SEEGER HOMES INC. - SALES OFFICE

SITE DEVELOPMENT PLANS
LOT 3, APPALOOSA HIGHWAY 24 SUBDIVISION

LIGHTING PLAN

Subject: Text Box
Page Label: [1] C-01
Author: dsdkendall
Date: 8/31/2018 2:05:37 PM
Color: ■

SHEET NO:
C-01

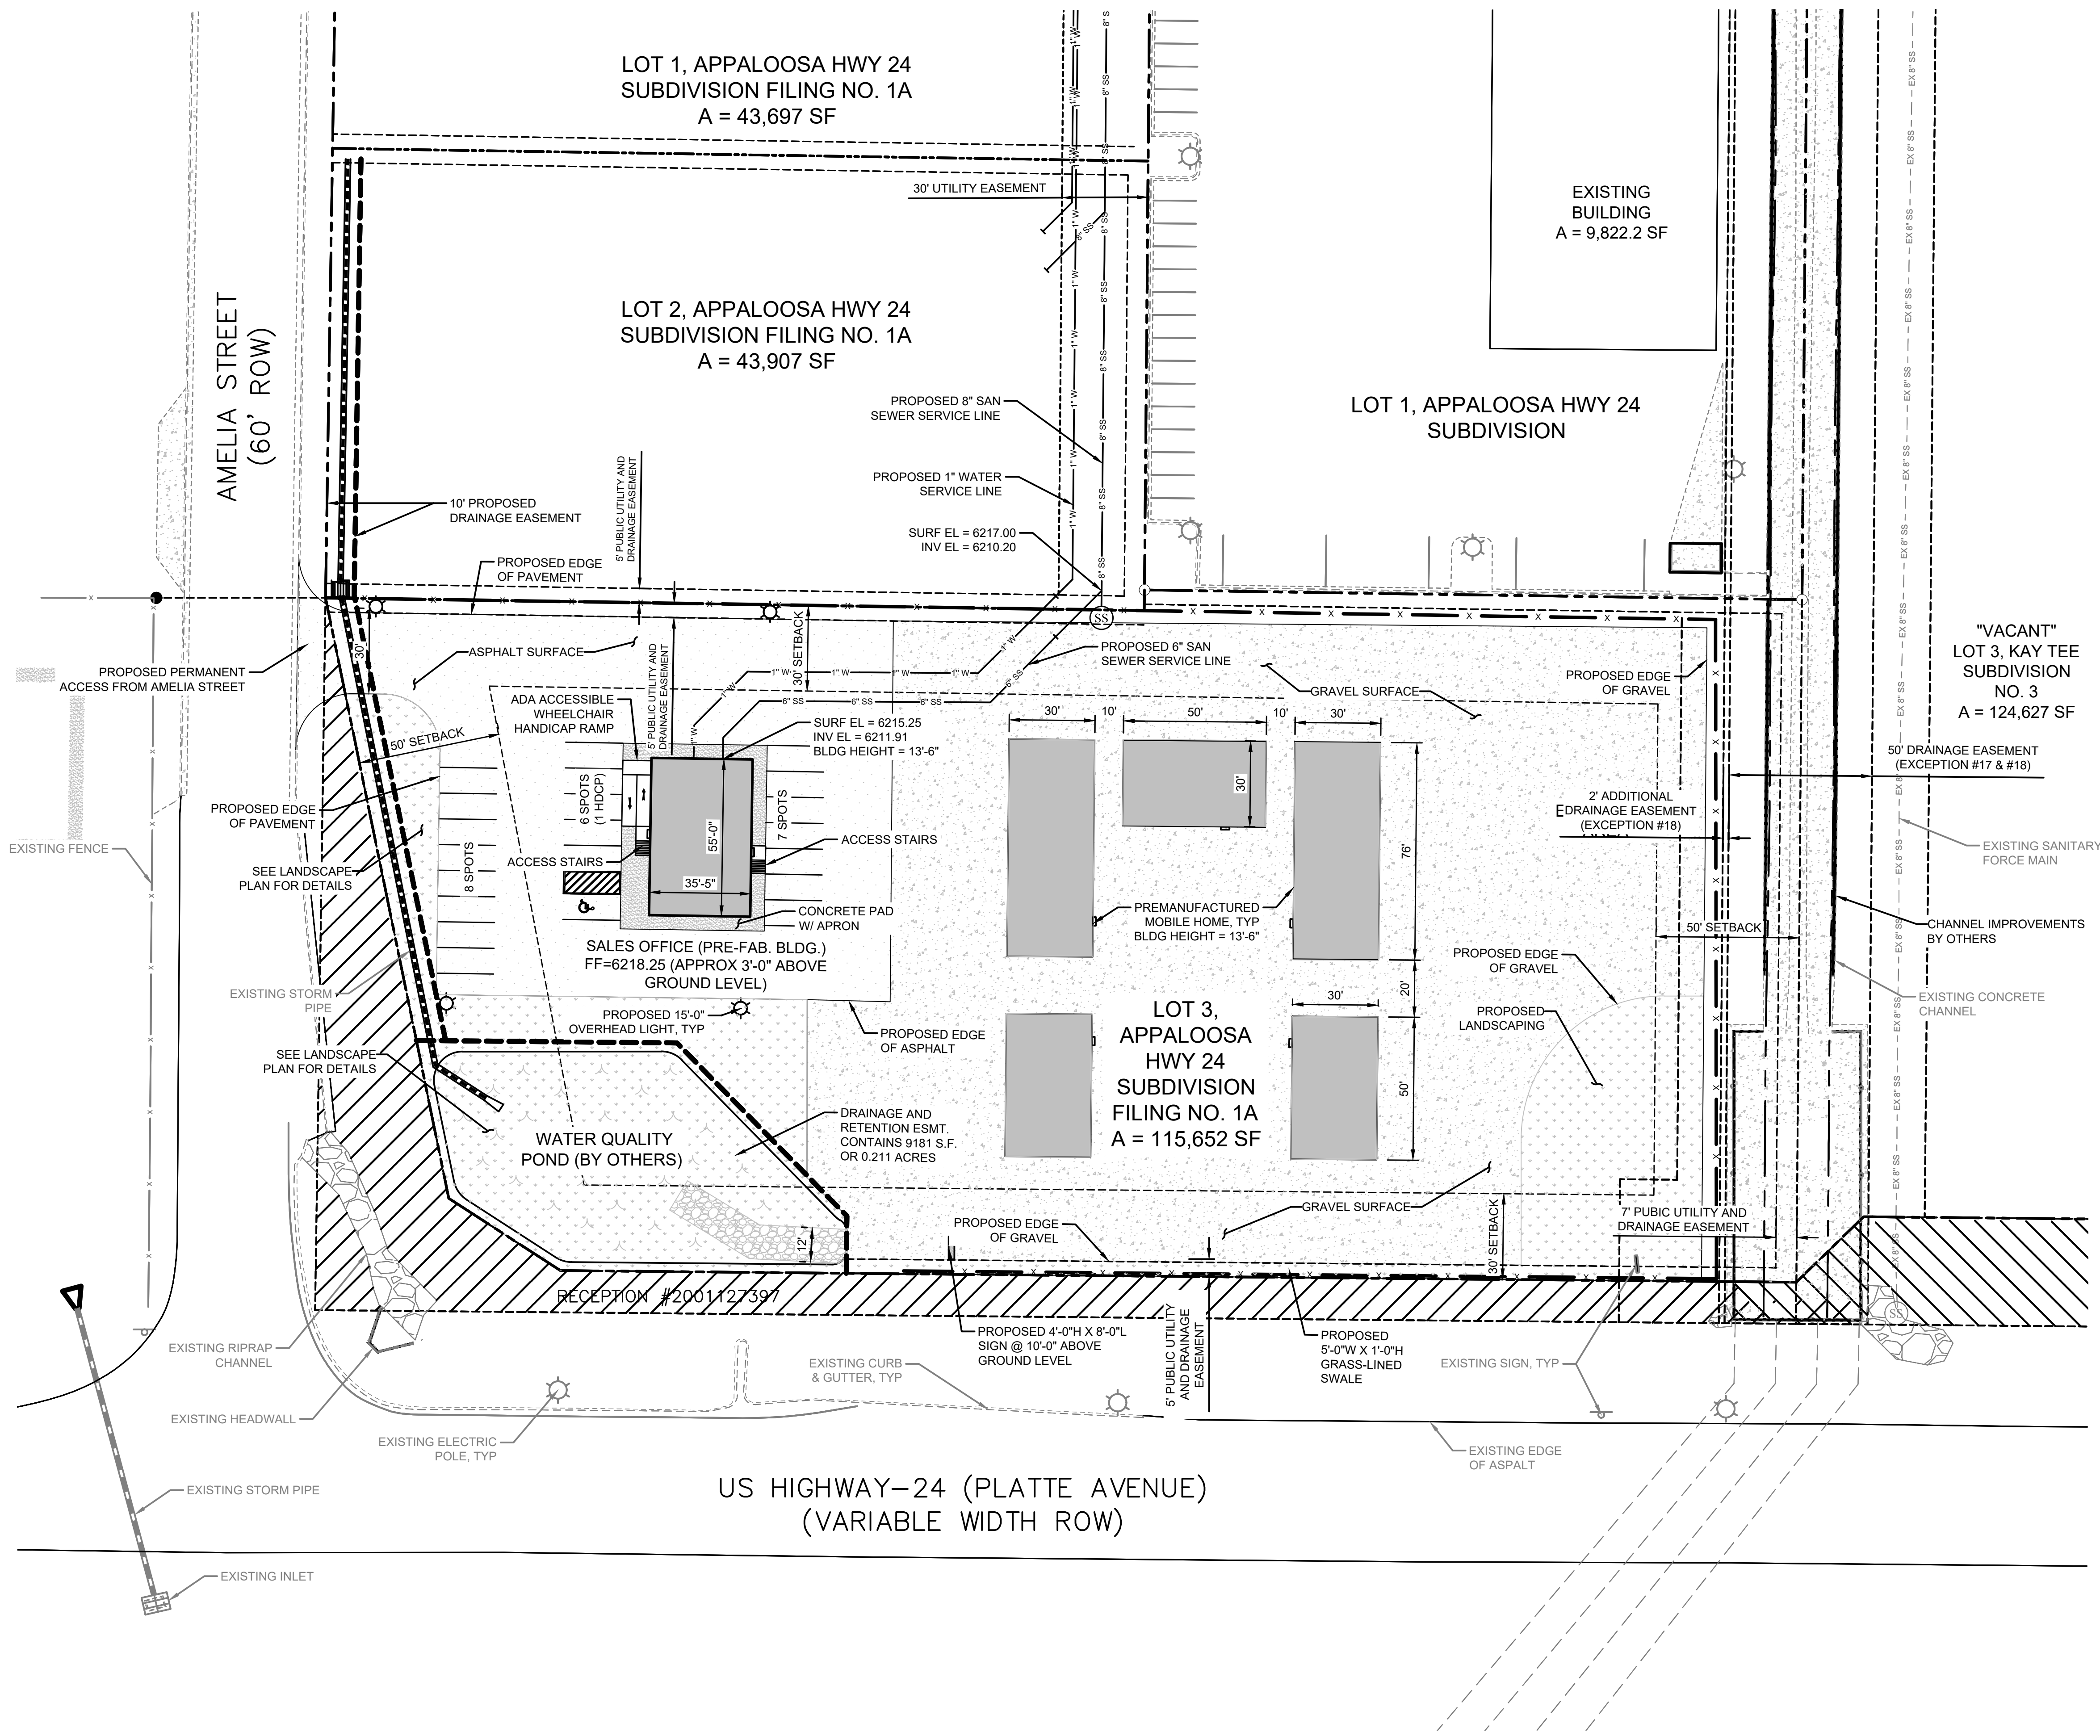
Maximum height for freestanding light fixtures is 15 feet unless in a parking lot, then it is 2 feet max.

Foot candles at property boundary adjacent to public right of way cannot exceed 0.1 foot candles.
